East Anglia ONE North and East Anglia TWO Offshore Windfarms

Applicants' Comments on East Suffolk Council's Deadline 5 Submissions

Applicant: East Anglia TWO and East Anglia ONE North Limited
Document Reference: ExA.AS-19.D6.V1
SPR Reference: EA1N_EA2-DWF-ENV-REP-IBR-001247

Date: 24th February 2021
Revision: Version 1
Author: Royal HaskoningDHV

m

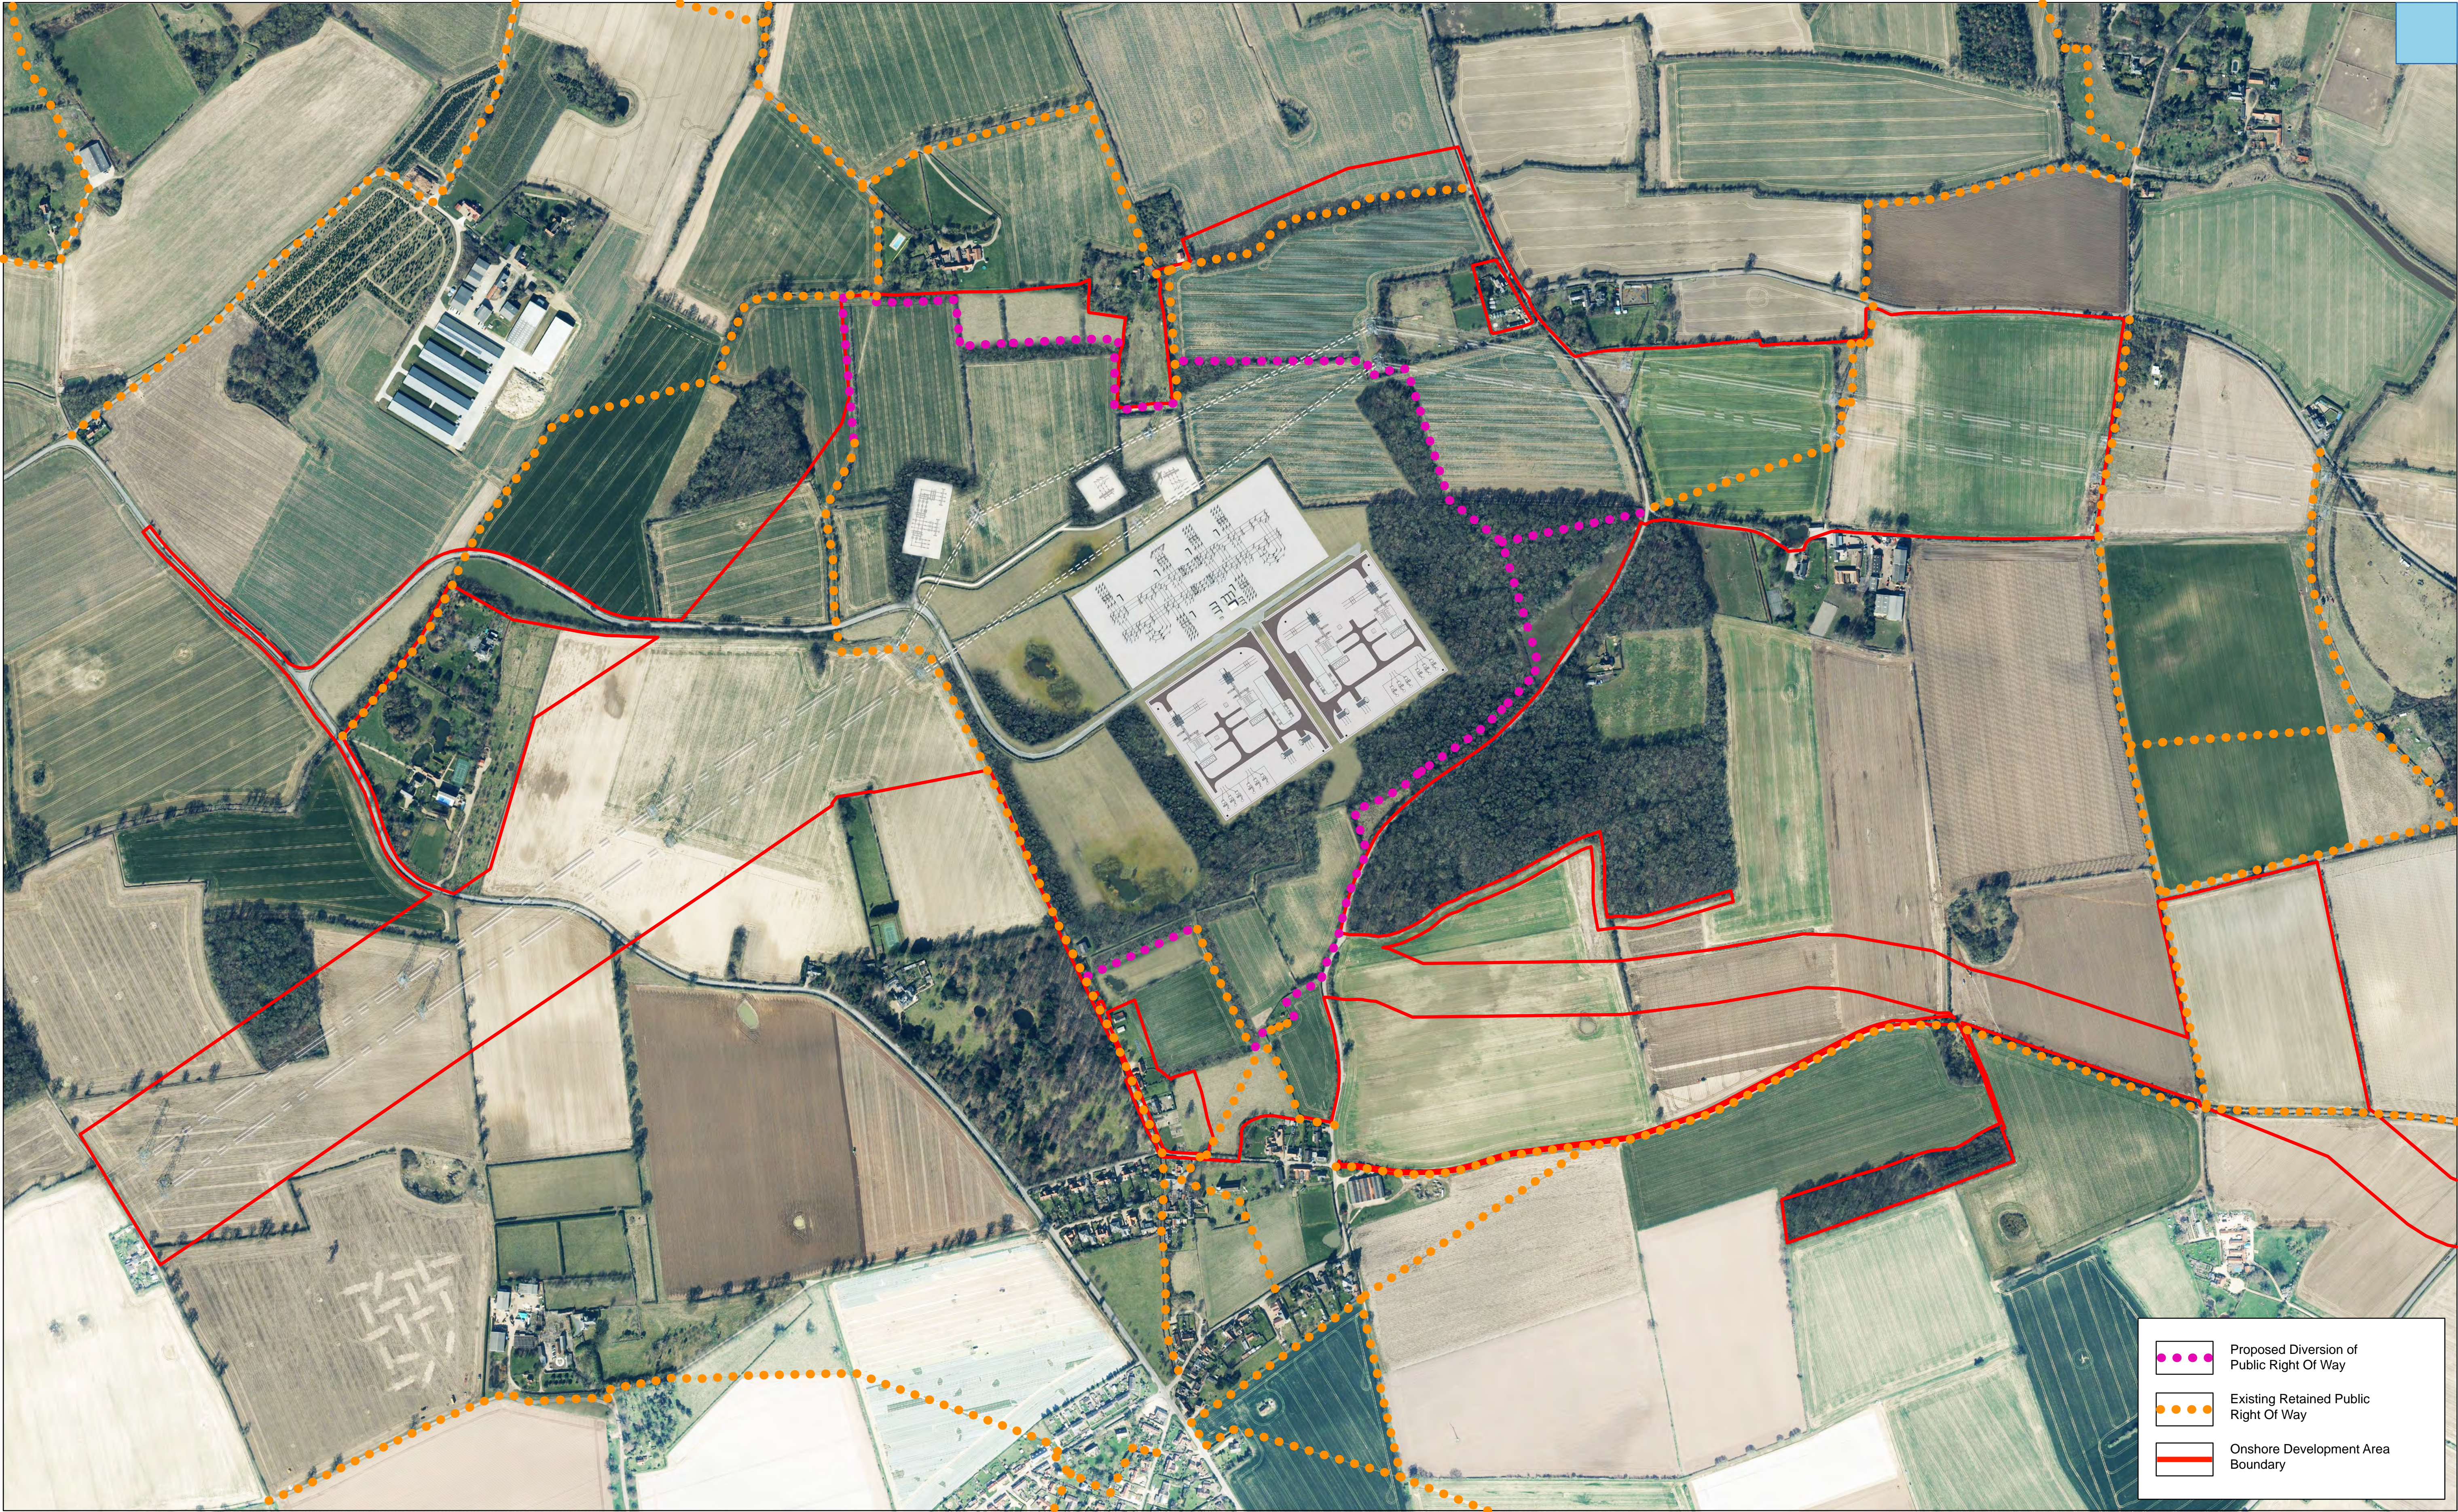
ID	ESC's Deadline 5 Comment	Applicants' Response
1	<p>The various new planting layout proposals are noted and accepted as an improvement on previous versions. The retention of existing tree cover to the west of the substations site is welcomed as is the newly proposed planting around the sealing end compounds and to the south of Little Moor Farm (as also noted in Paragraph 23 of Deadline 4 Project Update Note – REP4-026).</p> <p>ESC remains disappointed that National Grid have not engaged with their supply chains to see if the footprints and heights of their substation infrastructure could be reduced.</p> <p>ESC welcomes the inclusion of the sealing end compounds within the scope of Requirement 12 of the DCOs. It is considered that relatively minor modifications to the siting of the infrastructure would allow the retention of existing field boundaries which would be beneficial.</p>	<p>The Applicants note that ESC welcomes the updated planting arrangements within the Outline Landscape Mitigation Plan (OLMP) (REP4-013) and the inclusion of sealing end compounds within the scope of Requirement 12 of the draft DCO (REP5-003).</p>
